DRB Application No.: 06DRB-00448 (SBP)  
Project Name Rinconada Point, Unit 1  
Agent: Brasher & Lorenz Inc.

DATE: April 10, 2006  
TO: Sheran Matson, DRB Chair  
FROM: Catalina Lehner, Planner *CL*  
RE: Project #1004672, PNM Unser Substation

DESCRIPTION OF REQUEST: SITE DEVELOPMENT PLAN FOR BUILDING PERMIT FOR ELECTRIC SUBSTATION

PNM PUBLIC SERVICE COMPANY OF NEW MEXICO		
ELEVATION VIEW		
115kV LAYOUT		
UNSER UNIT SUBSTATION		
DR: DK	TR:	DATE: 1/26/06
CKD:	OK:	SCALE: 1"=10'
APP:	ACAD FILE:	USS-17204 6/6
REV. NO.	USS17201

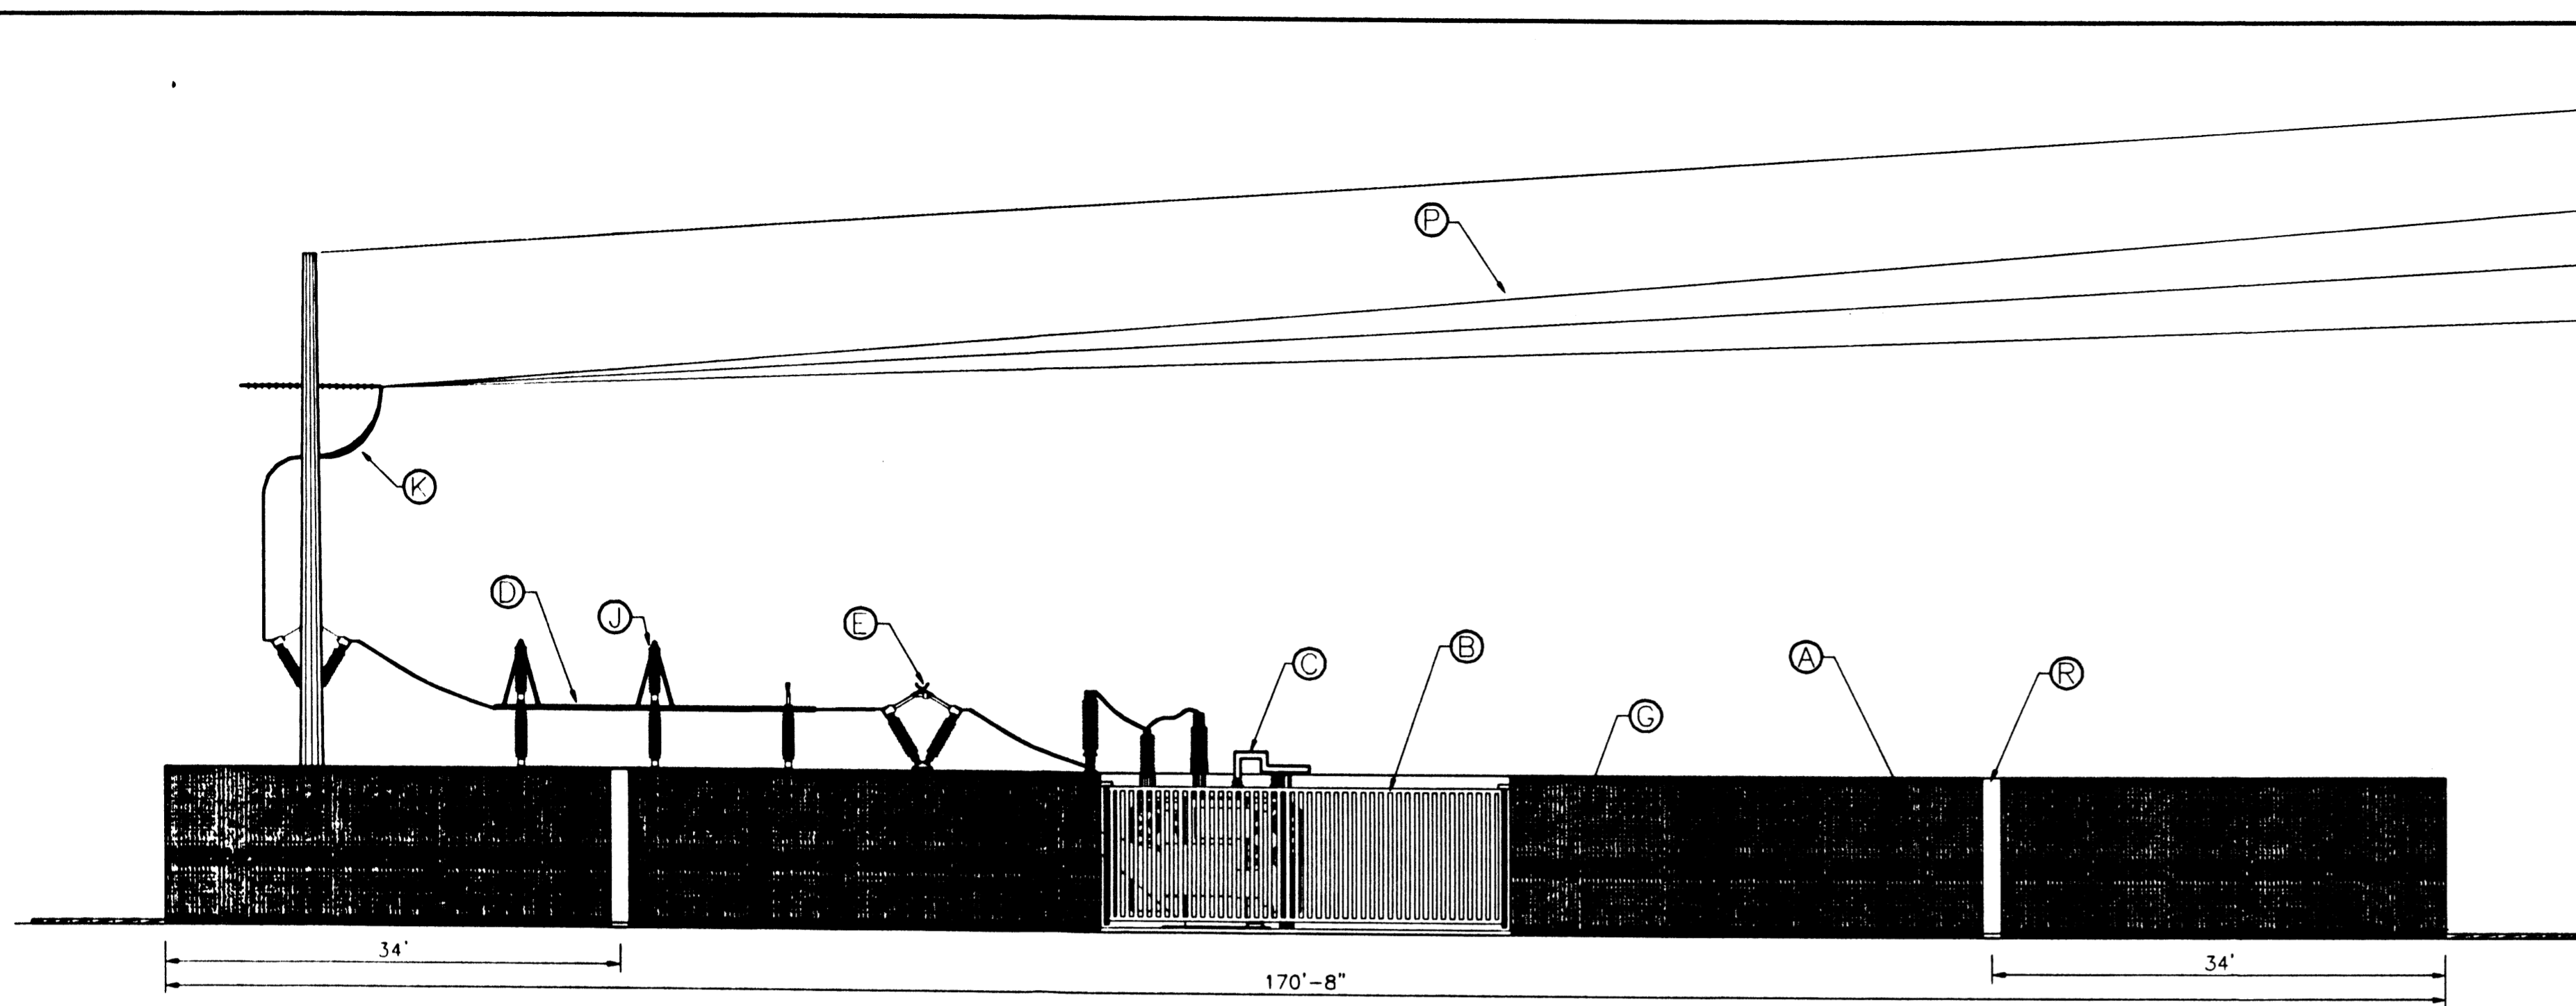
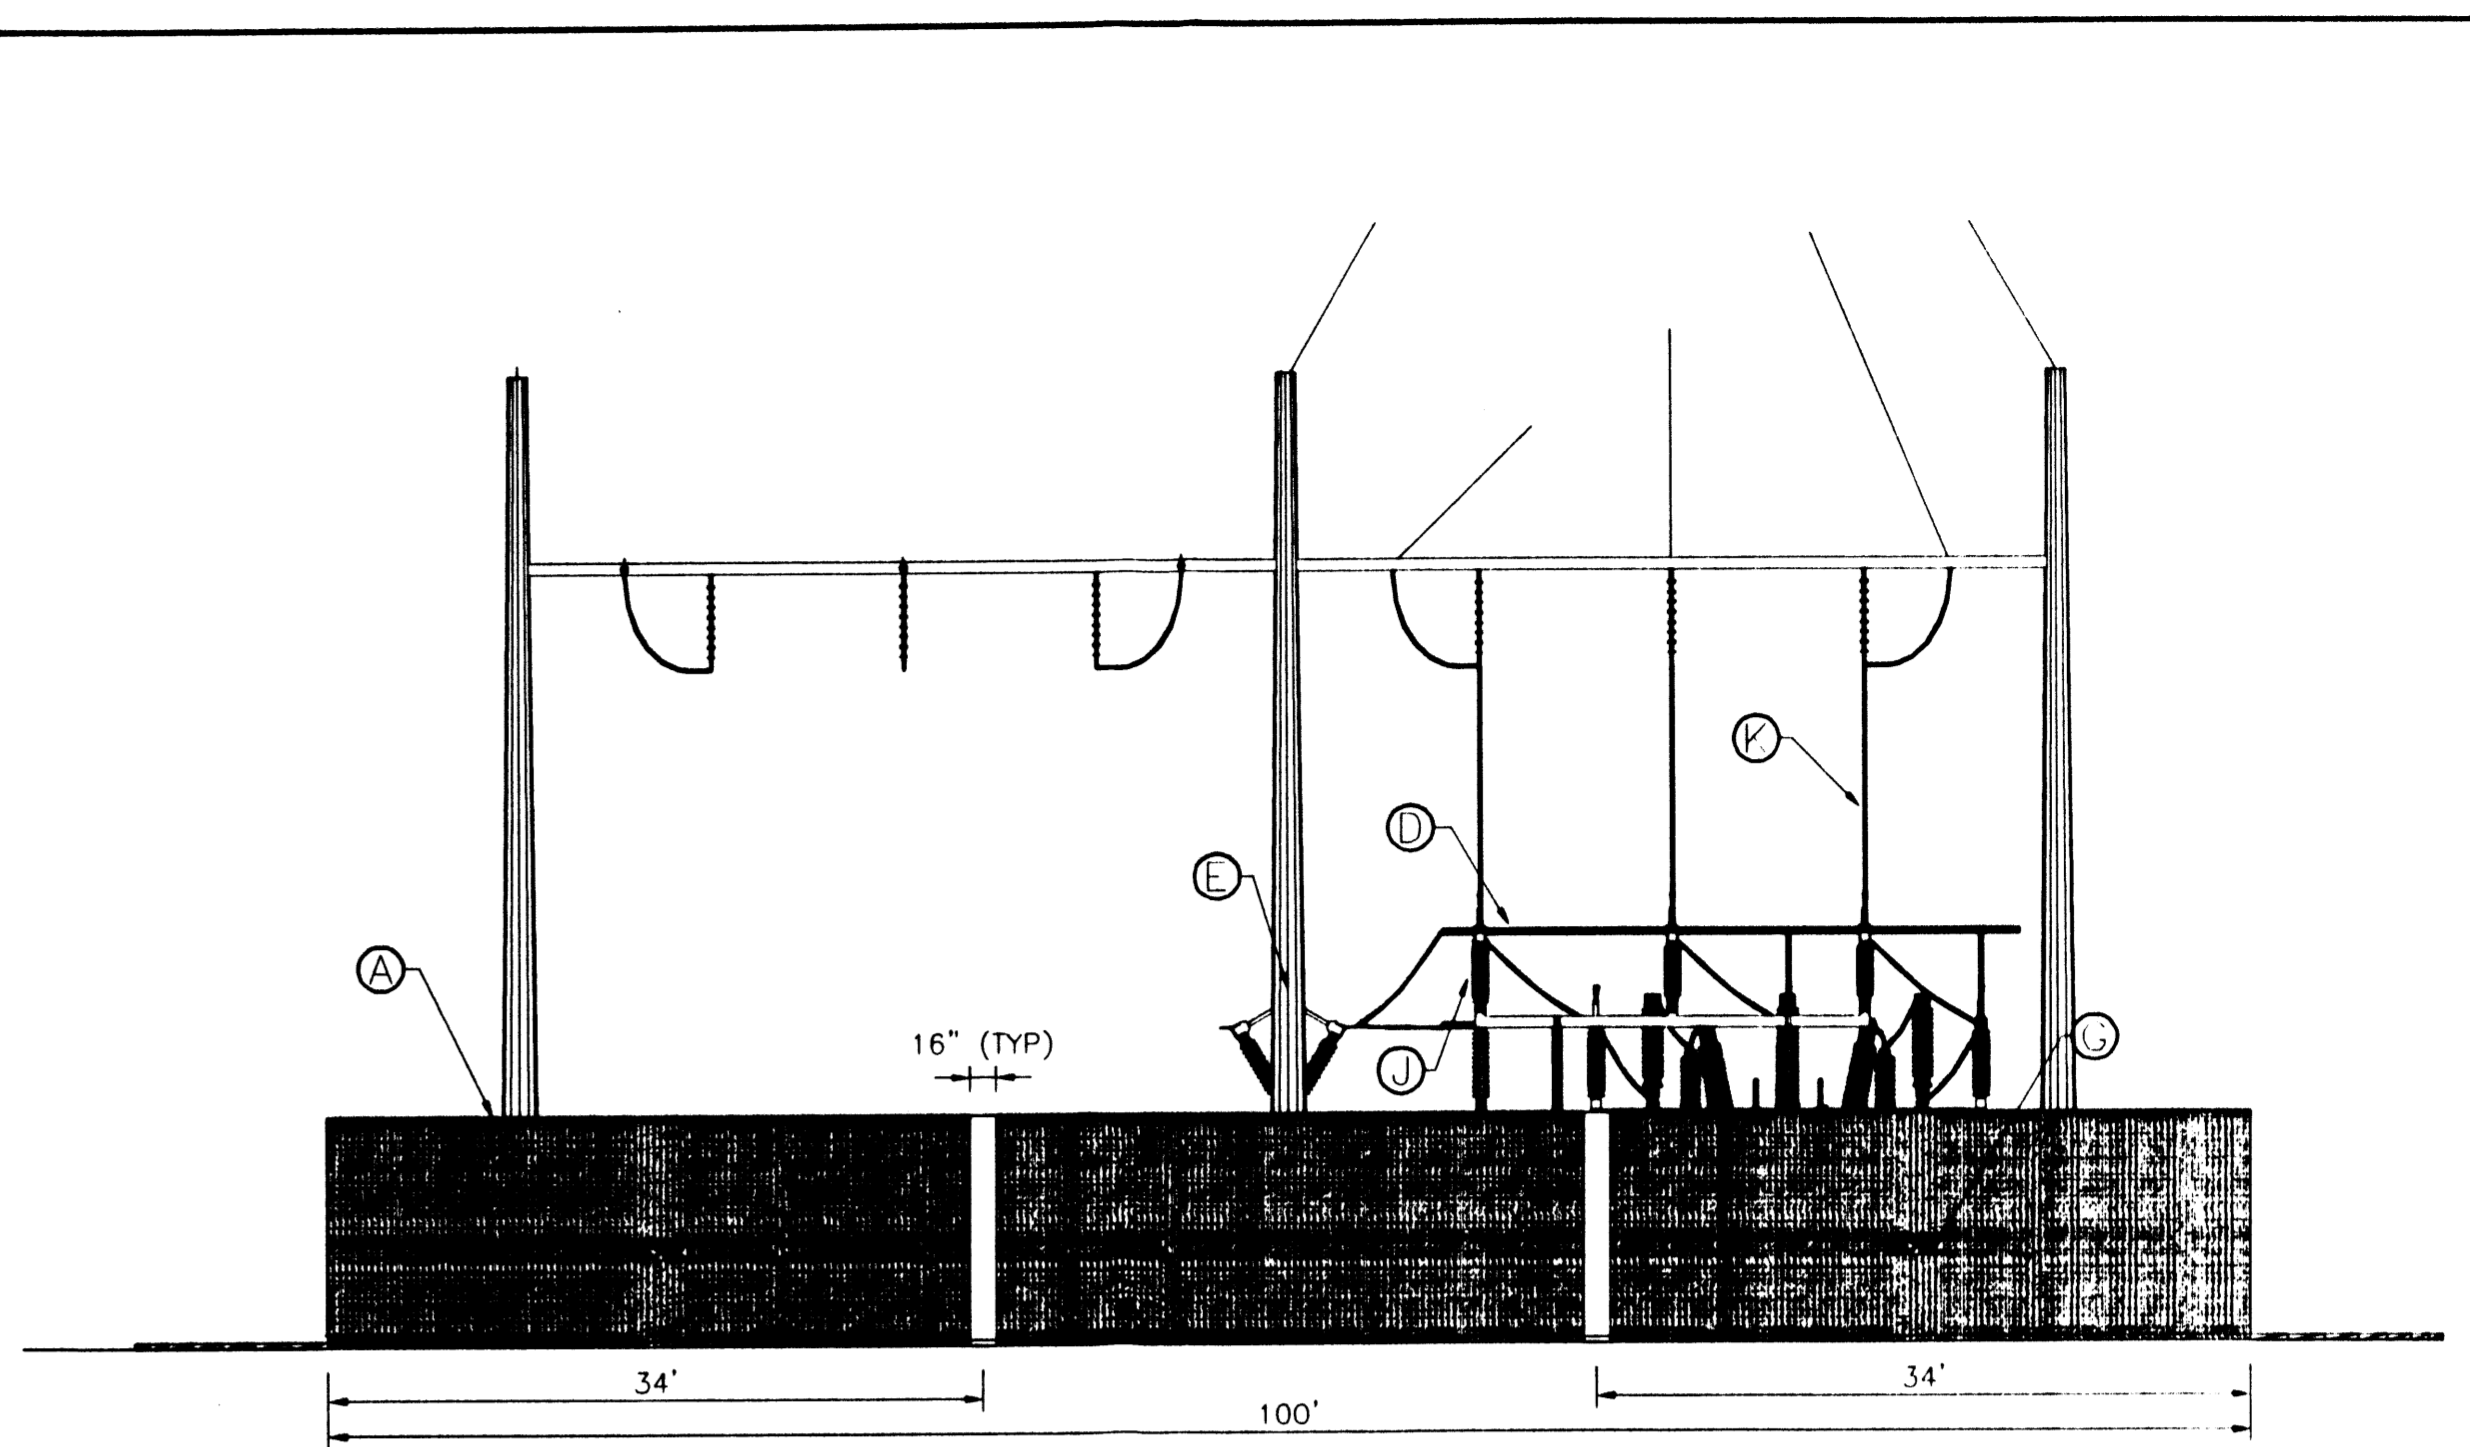
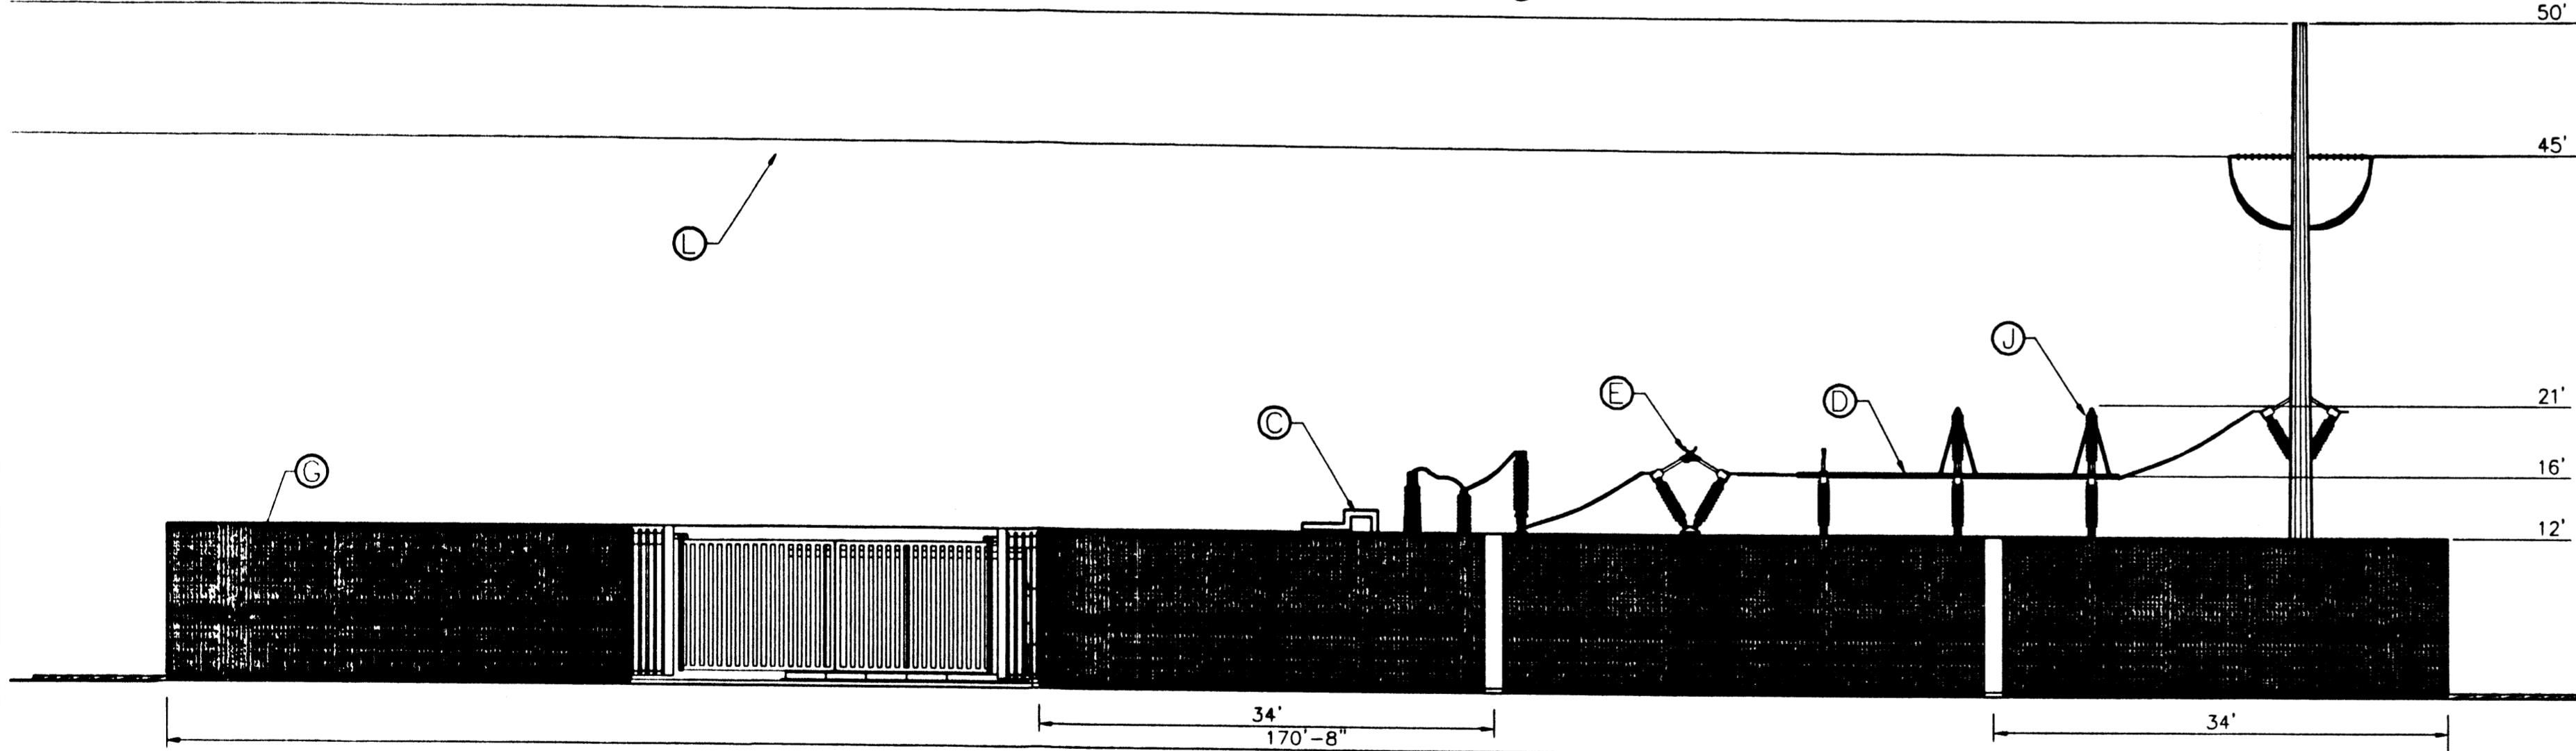
Condition #3 is intended to address Zoning Code §14-16-3-19, Section B (2)(a)-Wall Layout. Staff had recommended incorporation of a design feature. The applicant has added inlaid, smooth-face CMU columns on all wall façades, after 34 foot intervals. Development Review Staff finds this acceptable.
